RE: 53 Danforth Street – Portland, Maine

Following are responses to your comments for code review:

NORTH ELEVATION  
SCALE: 1/8" = 1'-0"

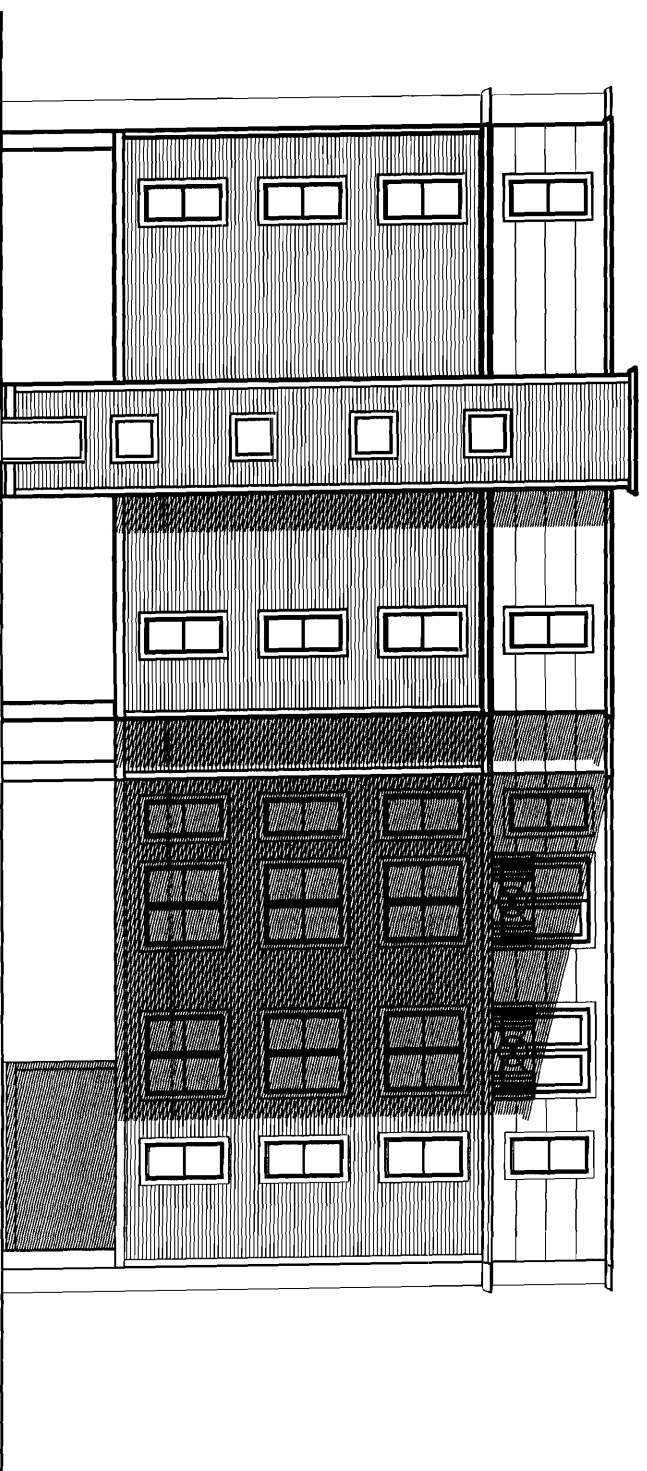
- c) (Original question 3) *Please provide an elevation to support the percentages of openings on the garage level of north elevation. **See attachment in email.***
